[REDACTED]
Subject: FW: 3 Arundel Road, Poling - PO/3/15/HH

Further to discussions with the Applicants, please find attached the revised proposals which I hope are suitable to be substituted for the proposed drawings within the householder application.

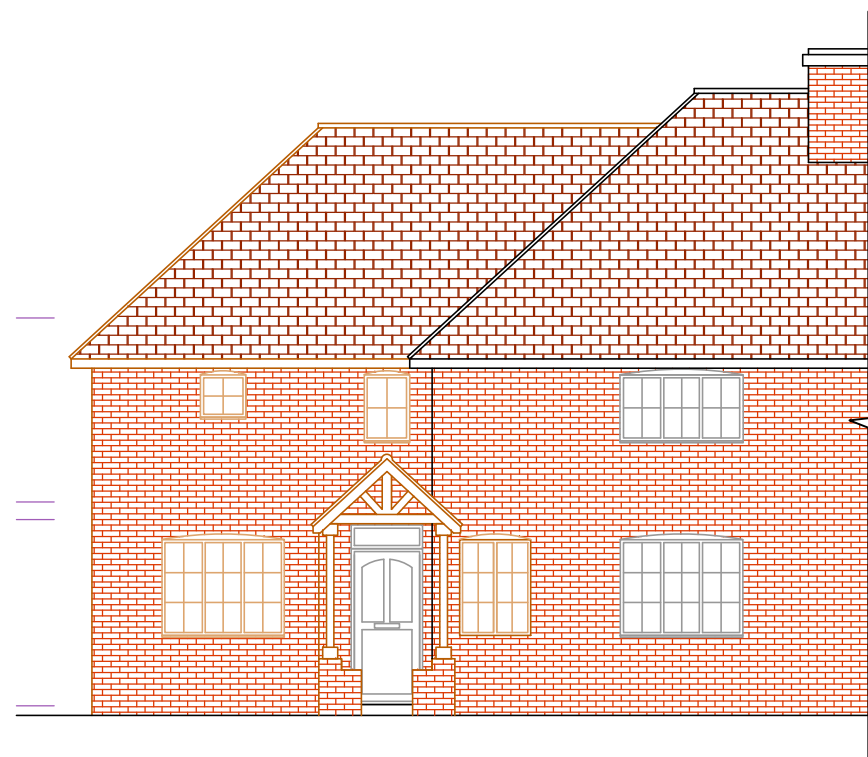
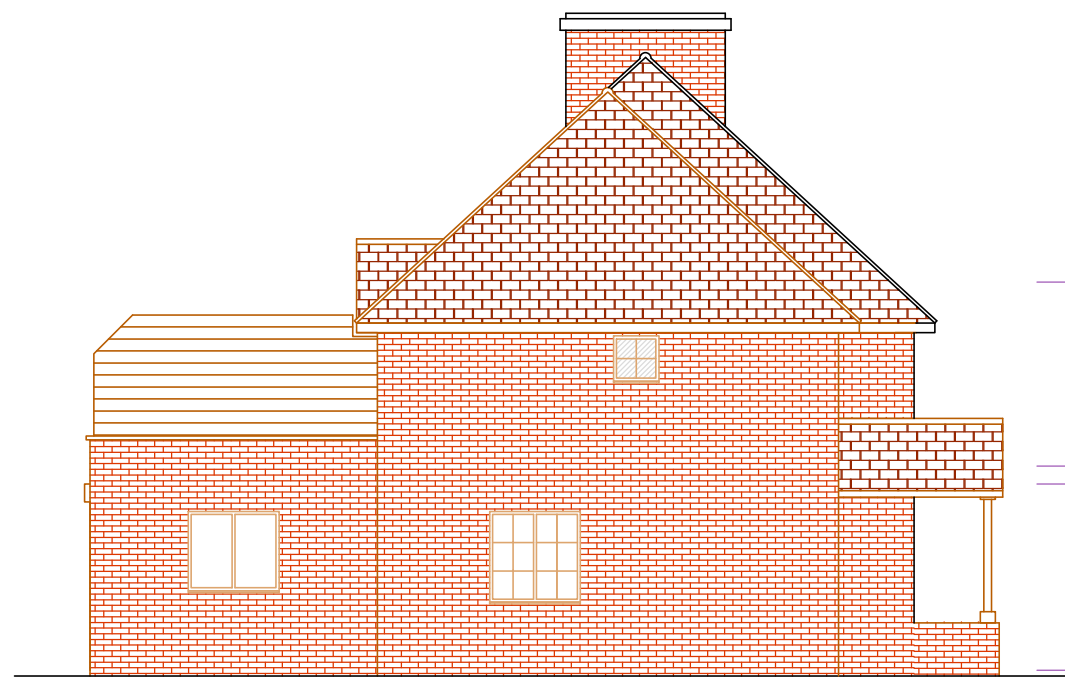
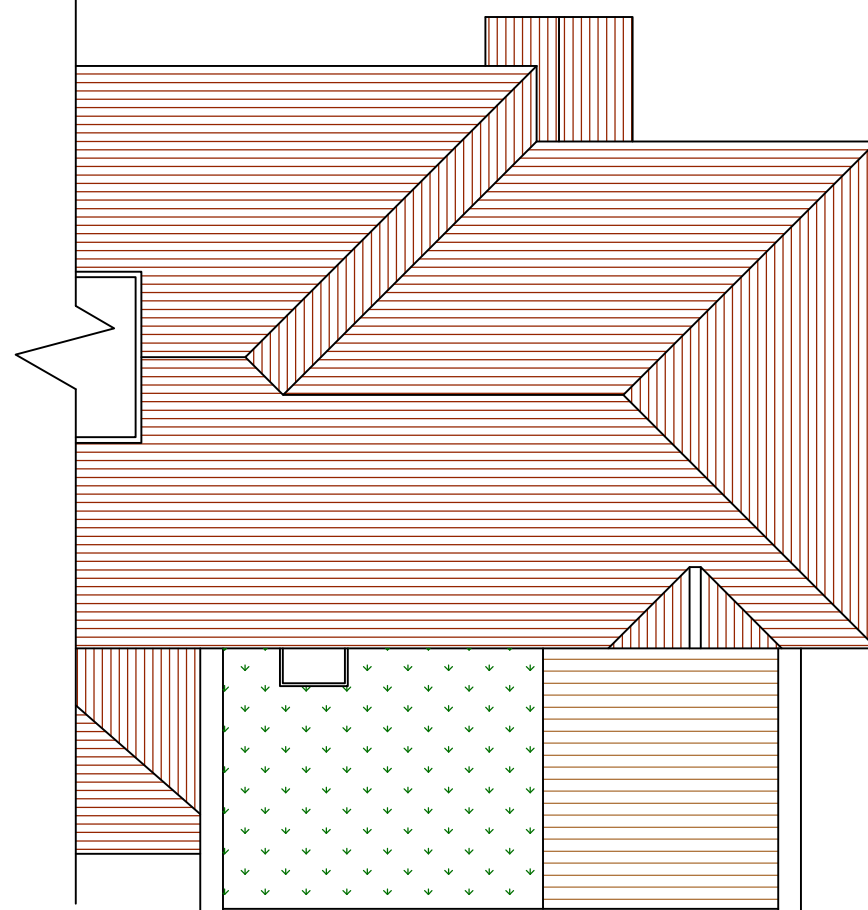
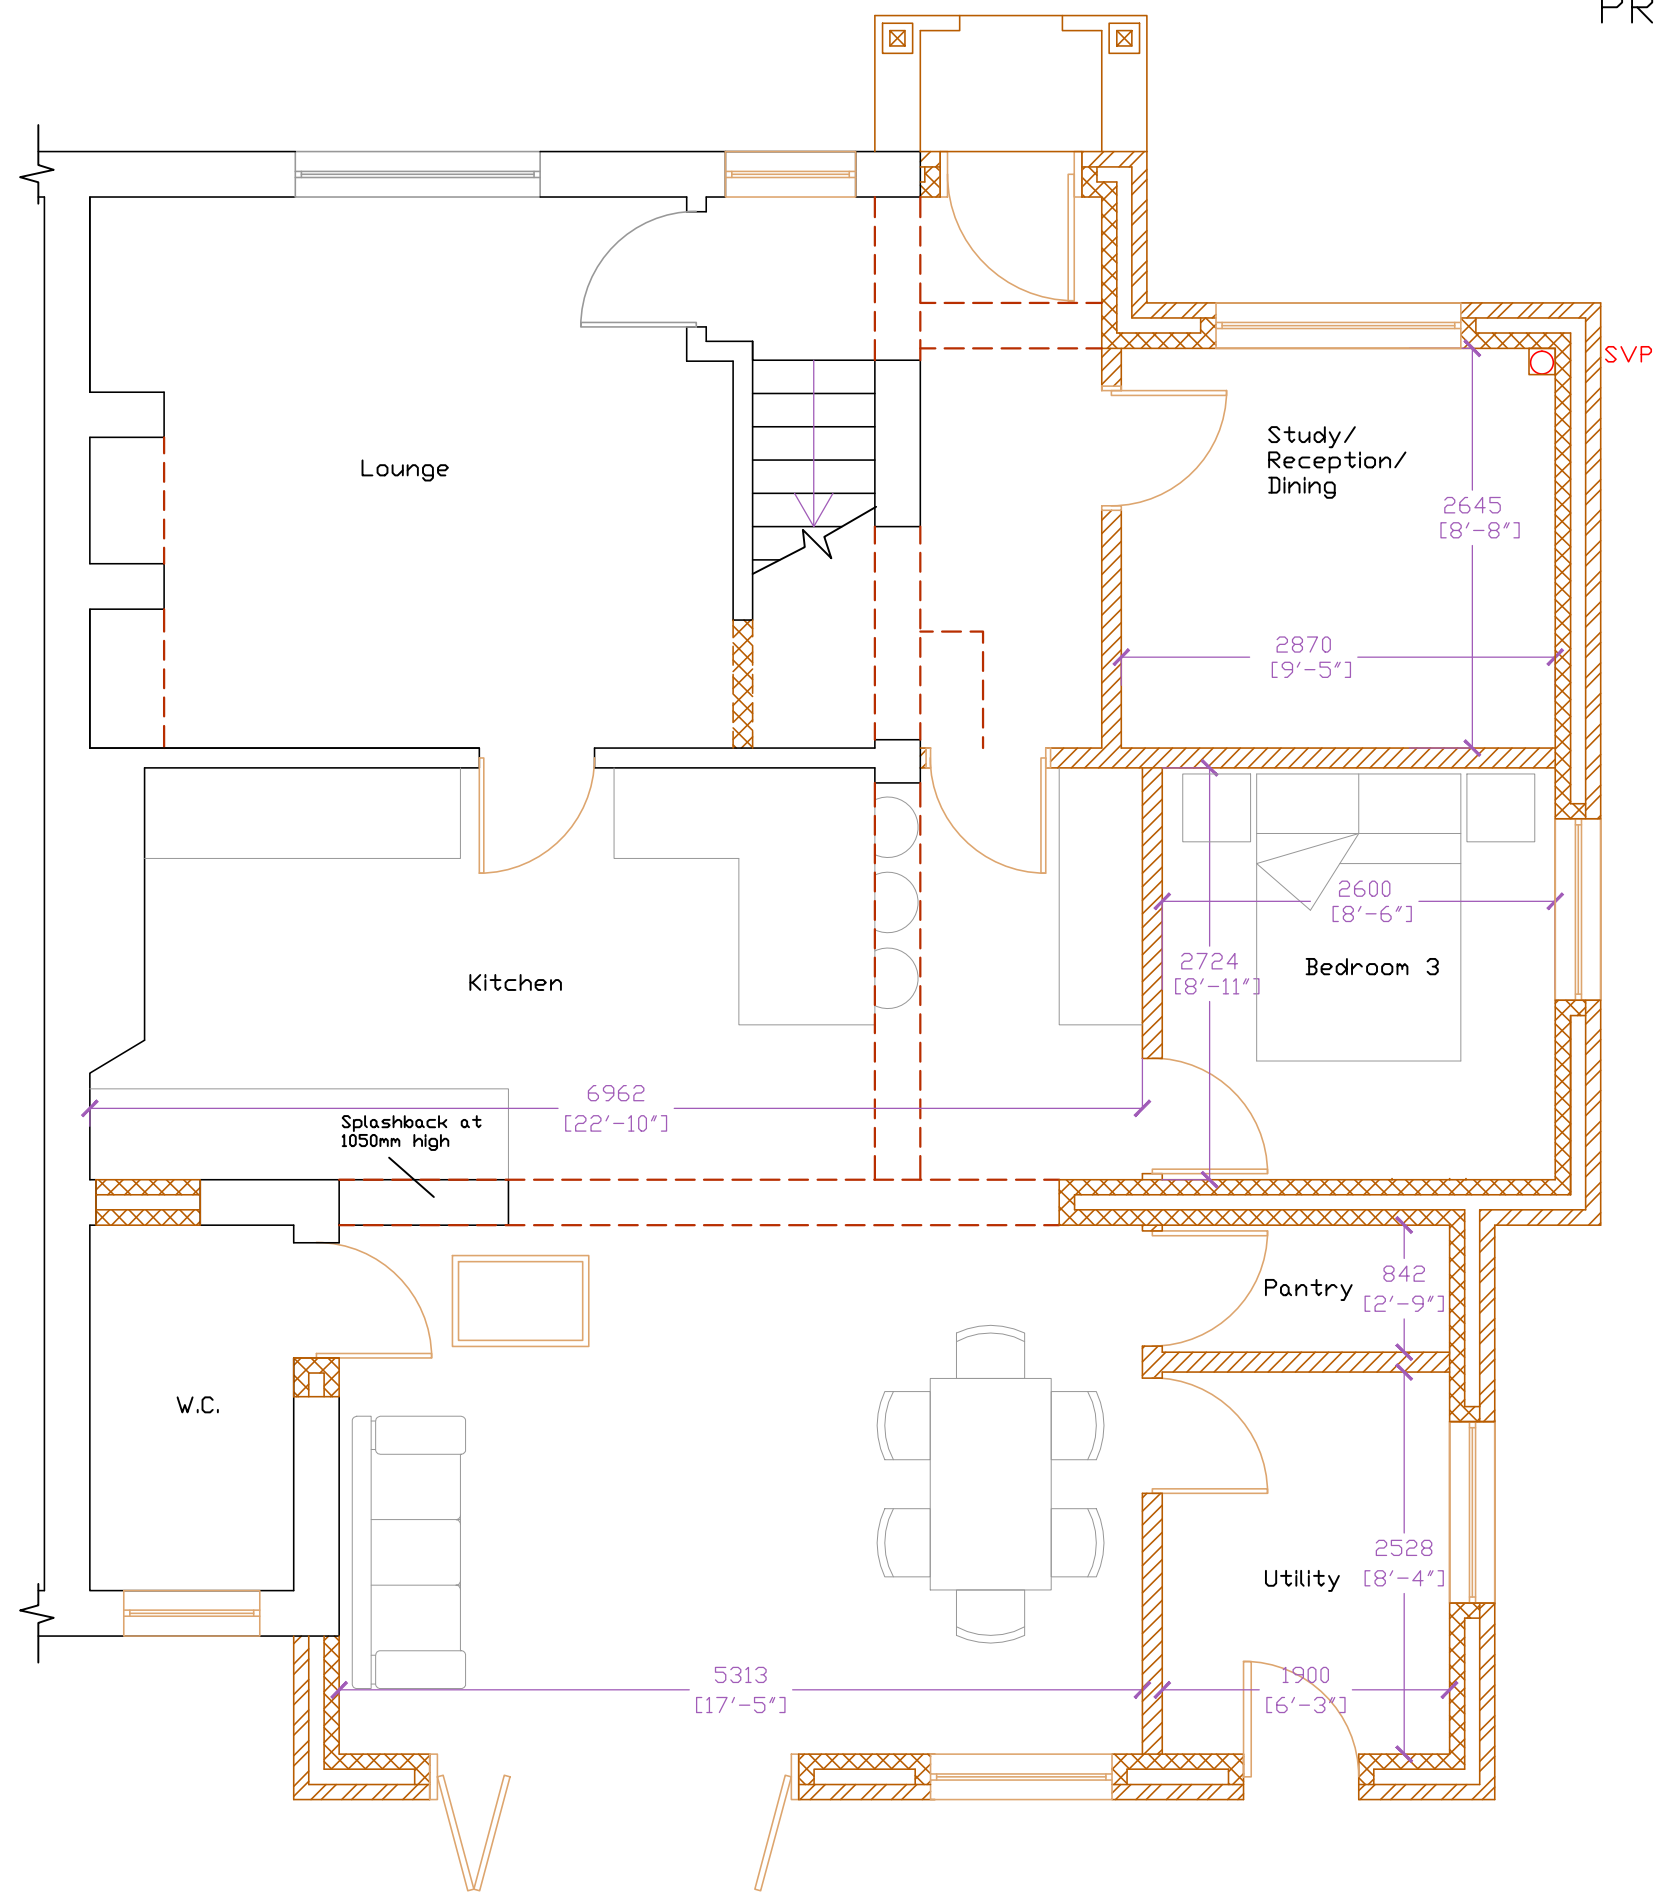
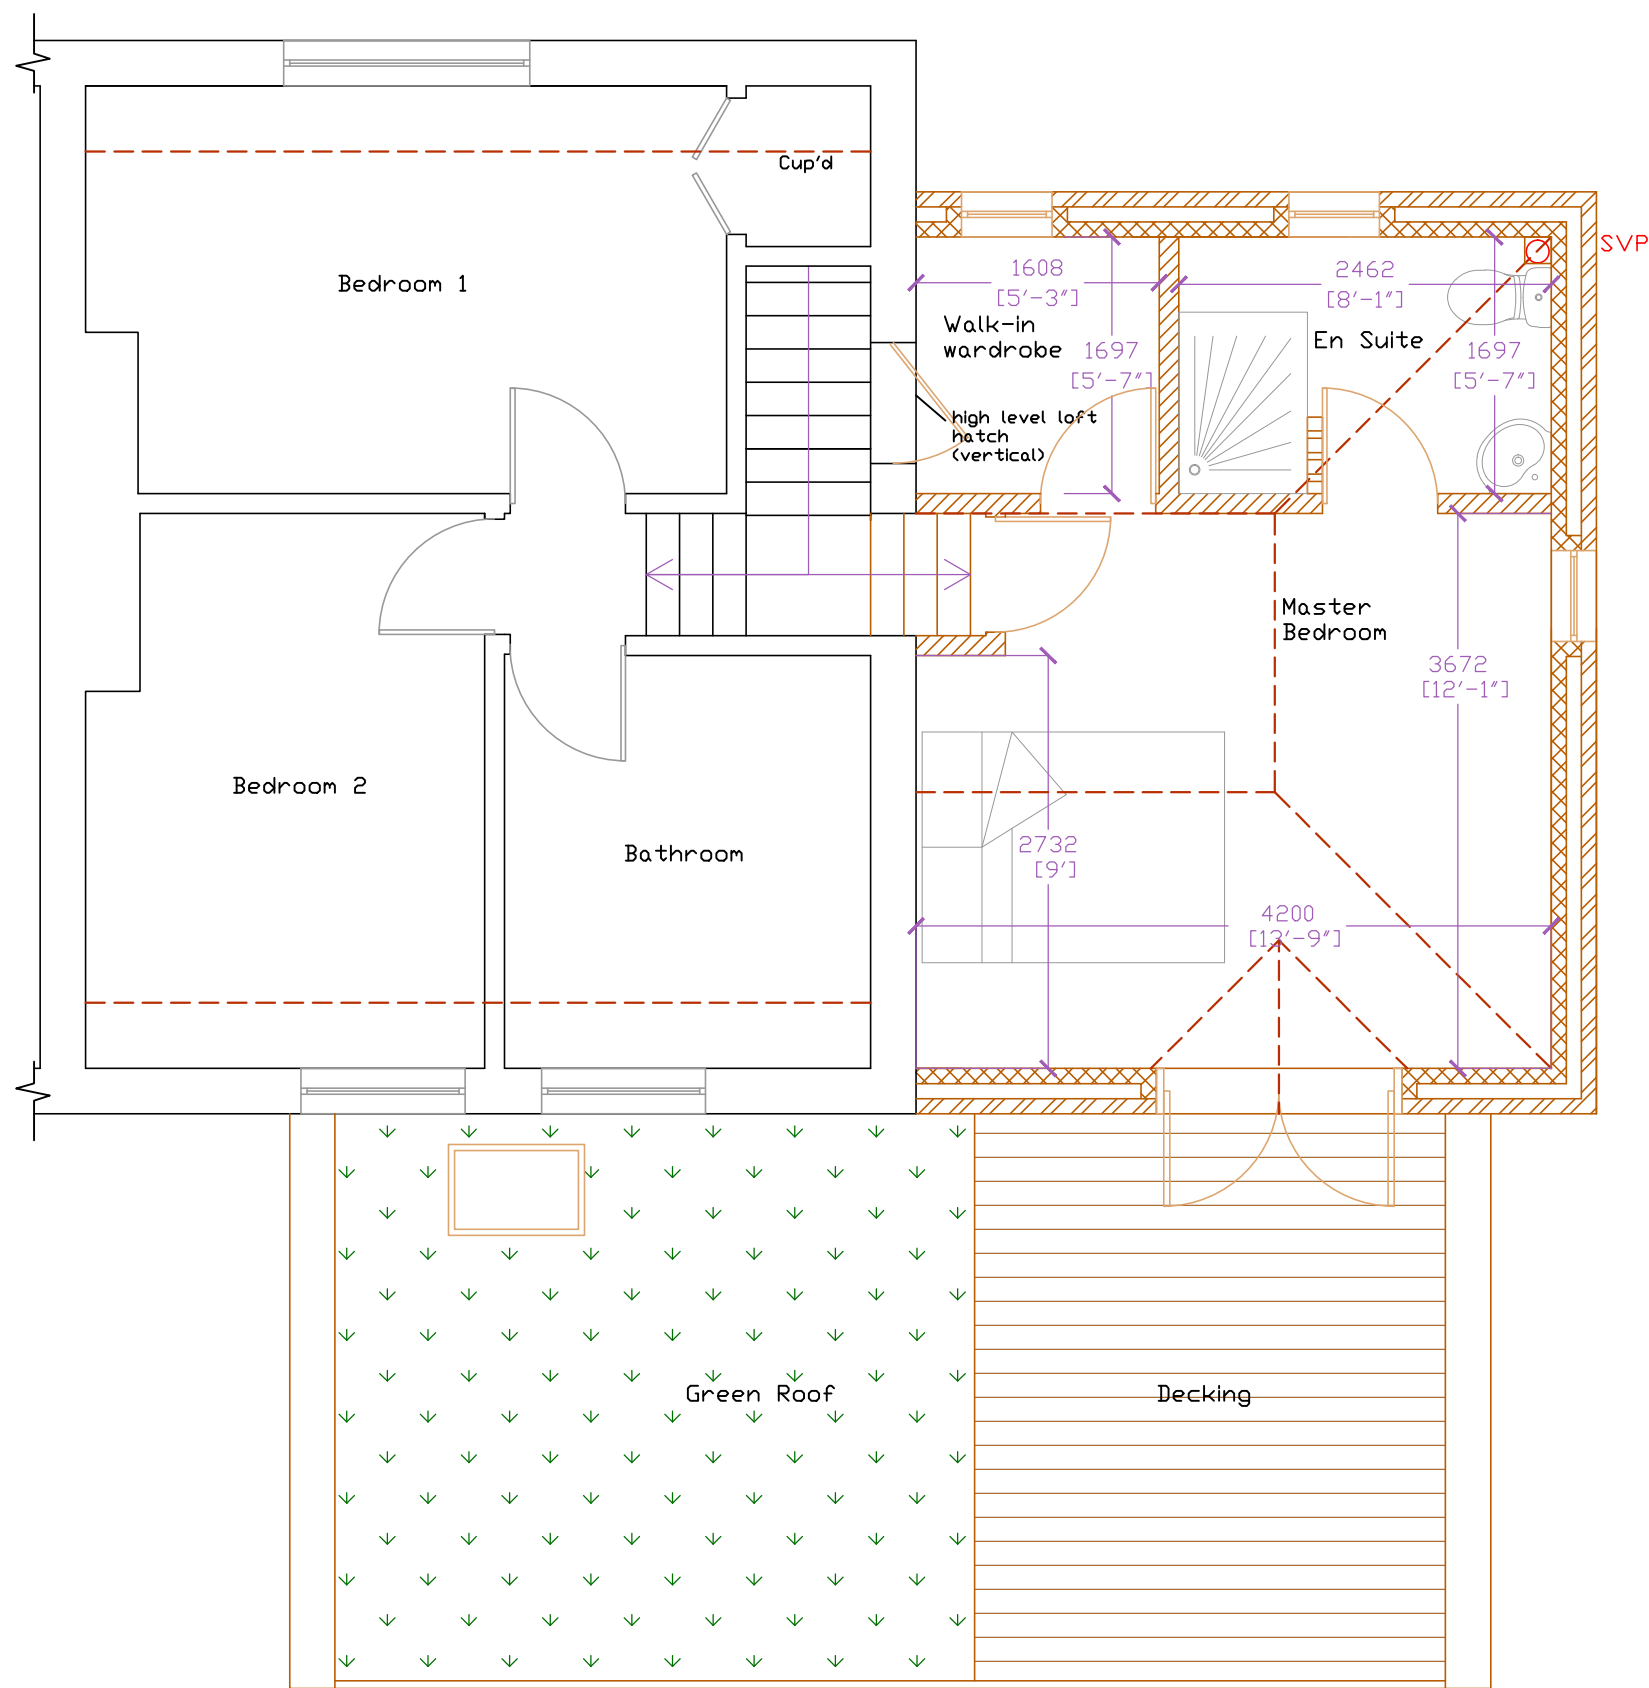
You will note that we have reduced the scheme's impact on the street scene by moving the front 2 storey wall back away from the front line of the house, which has also reduced the overall ridge height of the extension to a more subservient nature. I have taken on board your comments about the porch design and have reintroduced the design from the previous iteration, but have also incorporated the arrangement shown (in the attached) so as to satisfy the Building Regulations and the general circulation routes within the property – this is so that the occupants will be able to access the rooms from the hallway rather than having to enter other rooms.

PROPOSED REAR ELEVATION
South

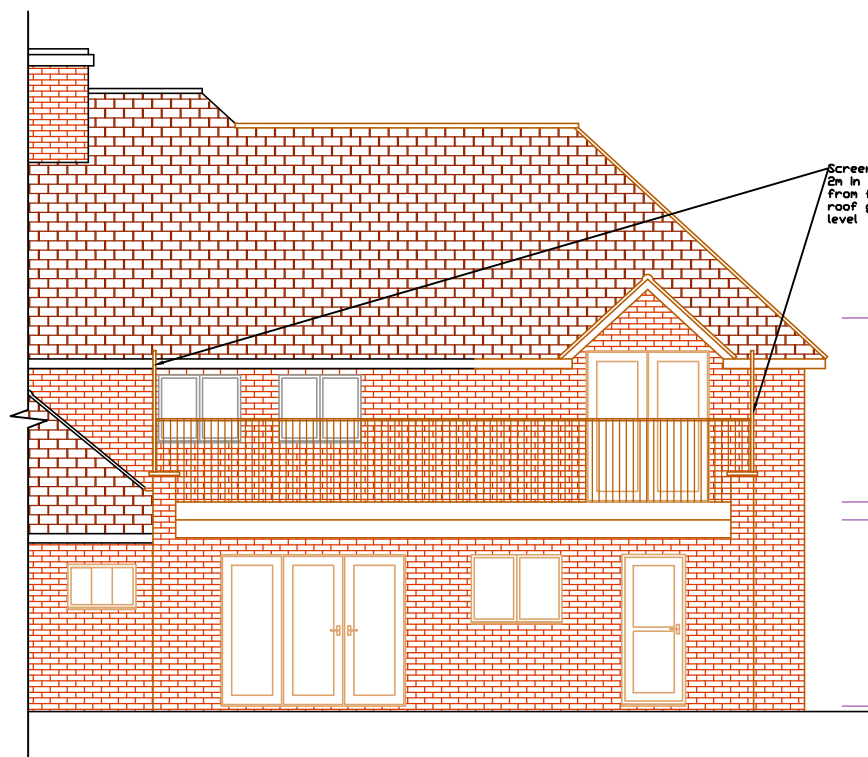
I'm sorry but the wrong rear elevation was featured on the last drawing --- please use this attached one with that aspect corrected (the extension ridge was too high).
